REF: LU/310/18/PL

17. 12. 2018

Dear Anita Gardner,
Re: Proposed Extension and Alterations /1 Arcade Road. Littlehampton.

DWG. NO / 021018 / TP.02

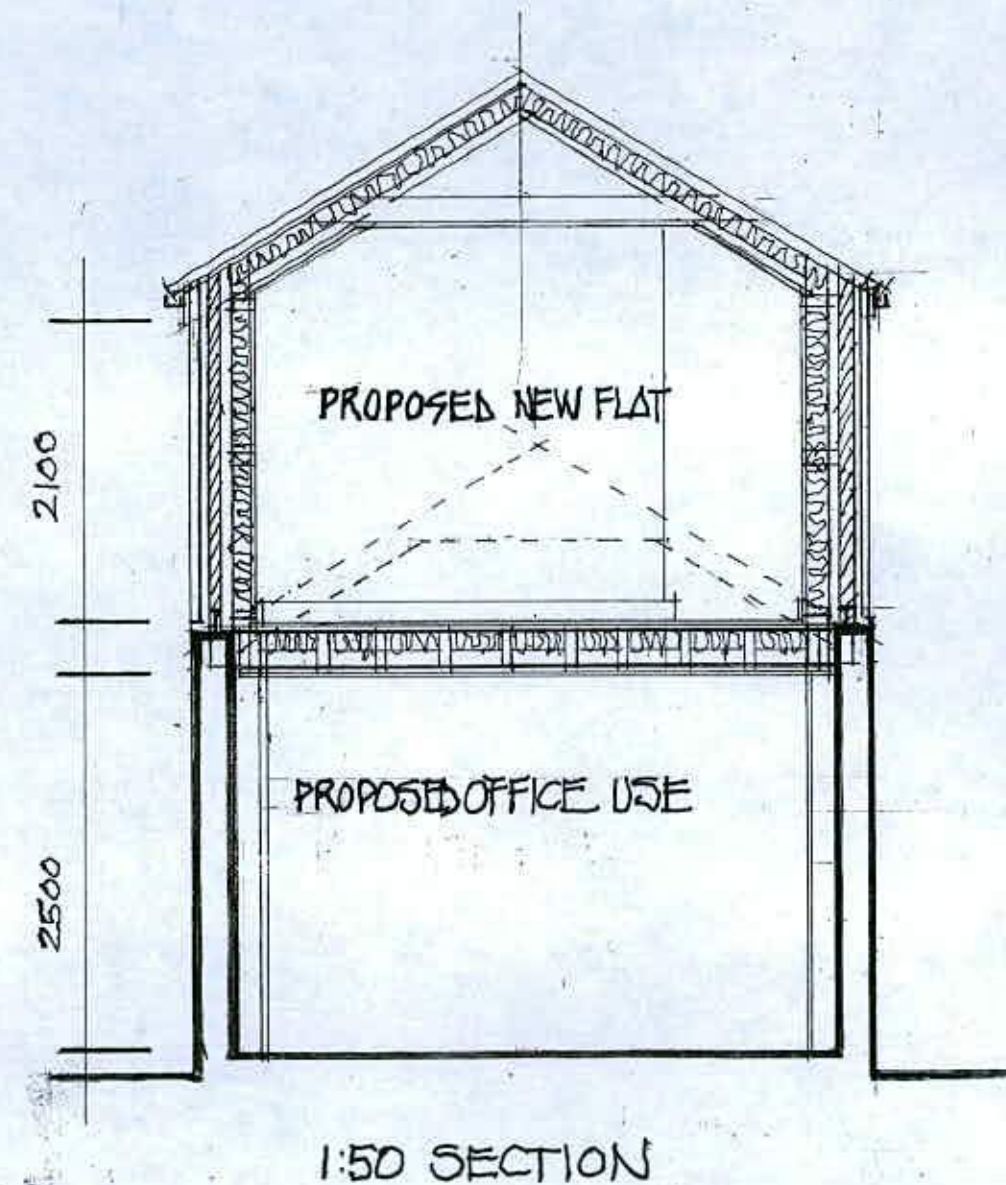
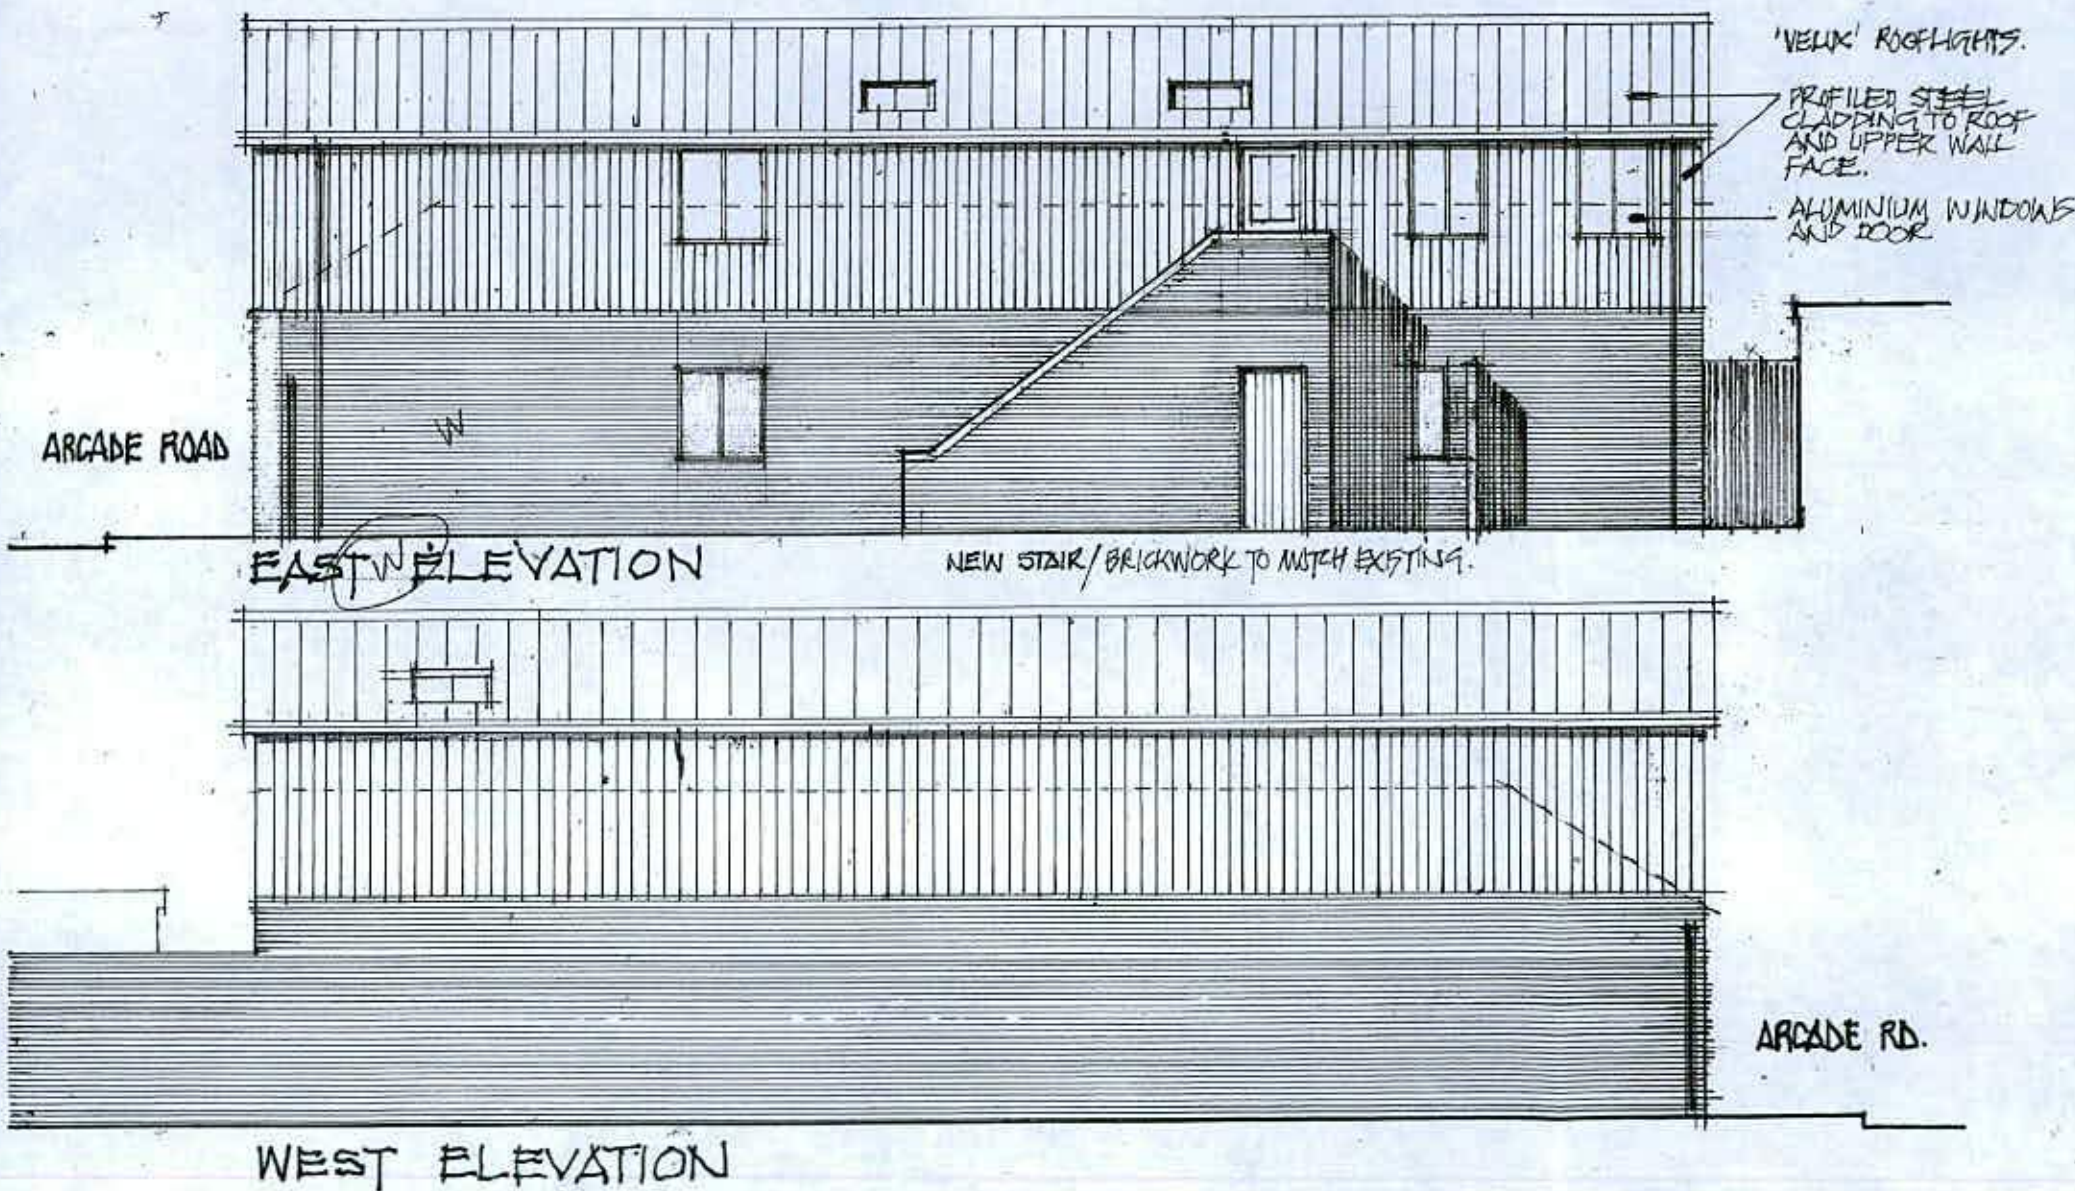
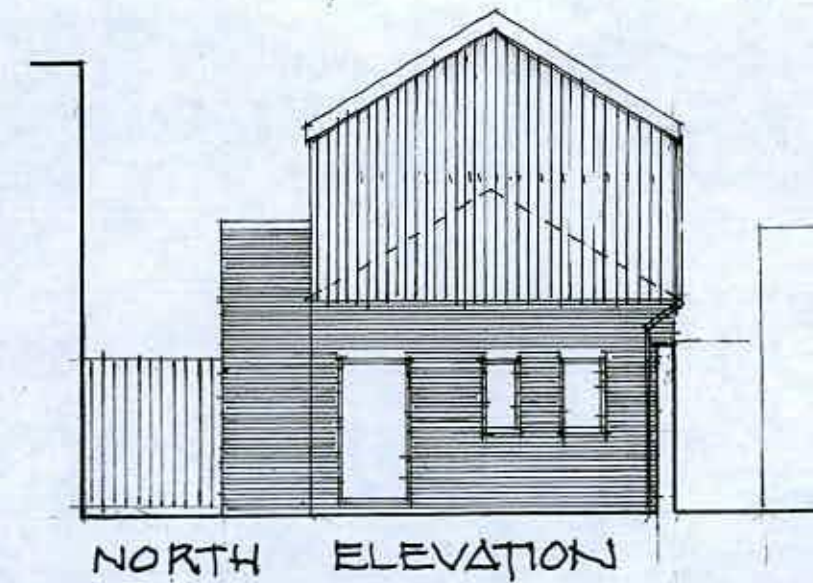
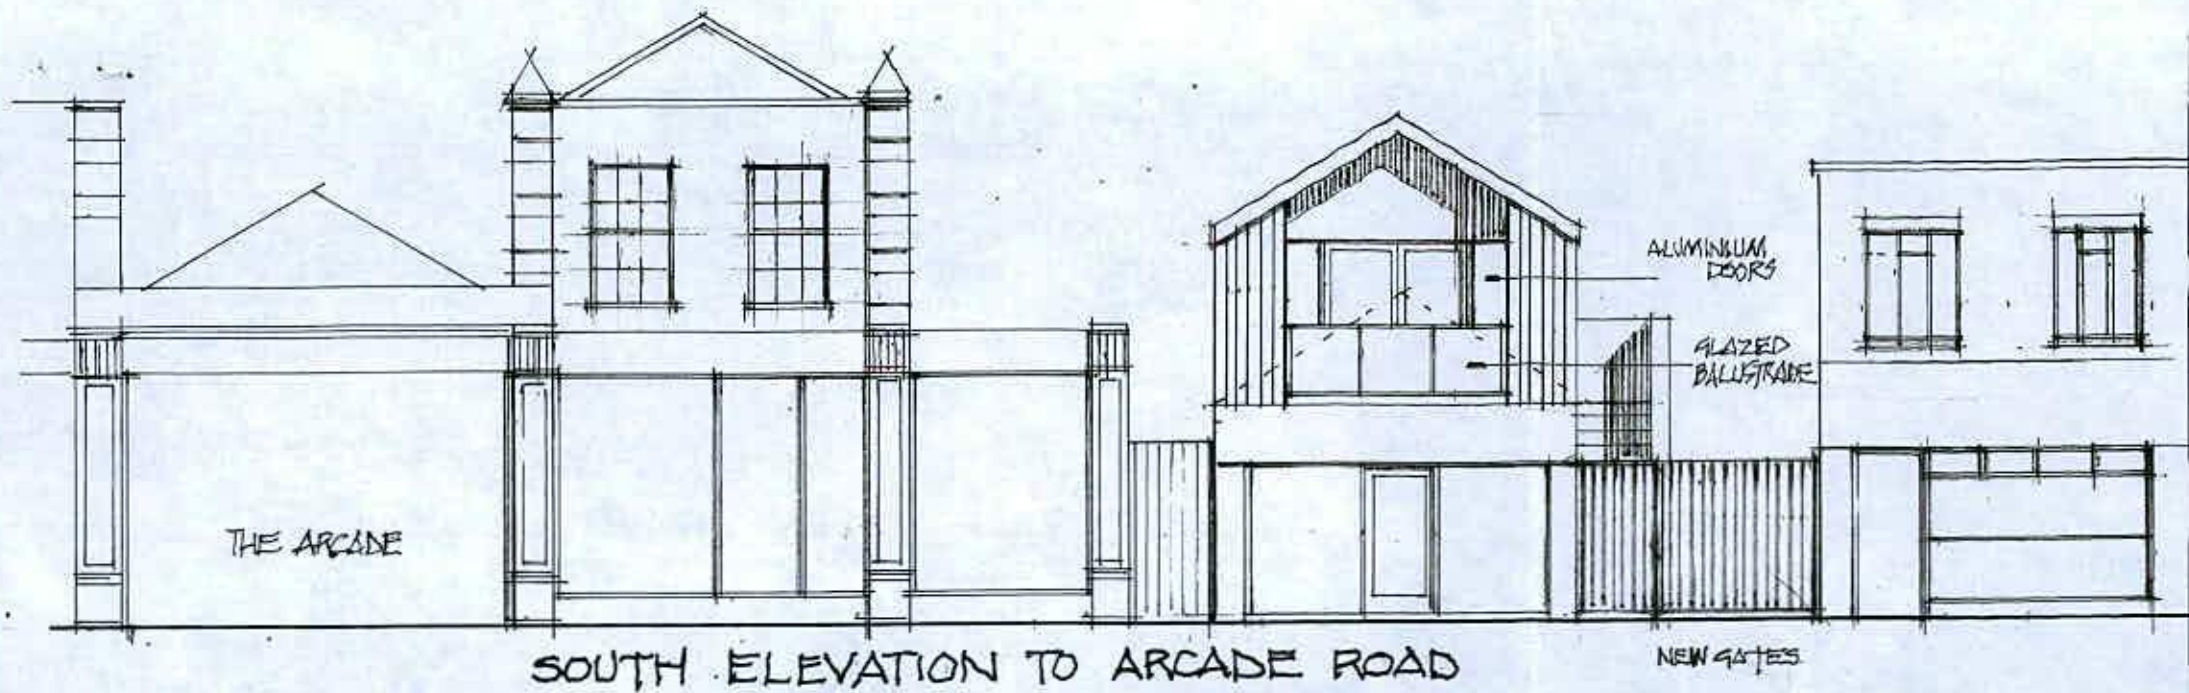
1. It does not state that he recommends either consent or refusal, which I take to mean that he has passed the decision back to you.
2. He refers to the amount of glazing to the street elevation however this is set back within the inset balcony and therefore will barely be visible from the street.
3. Reference is made to the choice of materials. The slate grey cladding does two things, firstly it reflects the slate roofing locally and secondly I believe that the original roof of the existing building was slated given the pitch which is too shallow to have been tiled.
4. He agrees that the change of use of the new upper floor is acceptable and the development could 'enhance' the appearance of the building.
5. I would add that the development will greatly improve the appearance of the existing building and provide some character to the street.
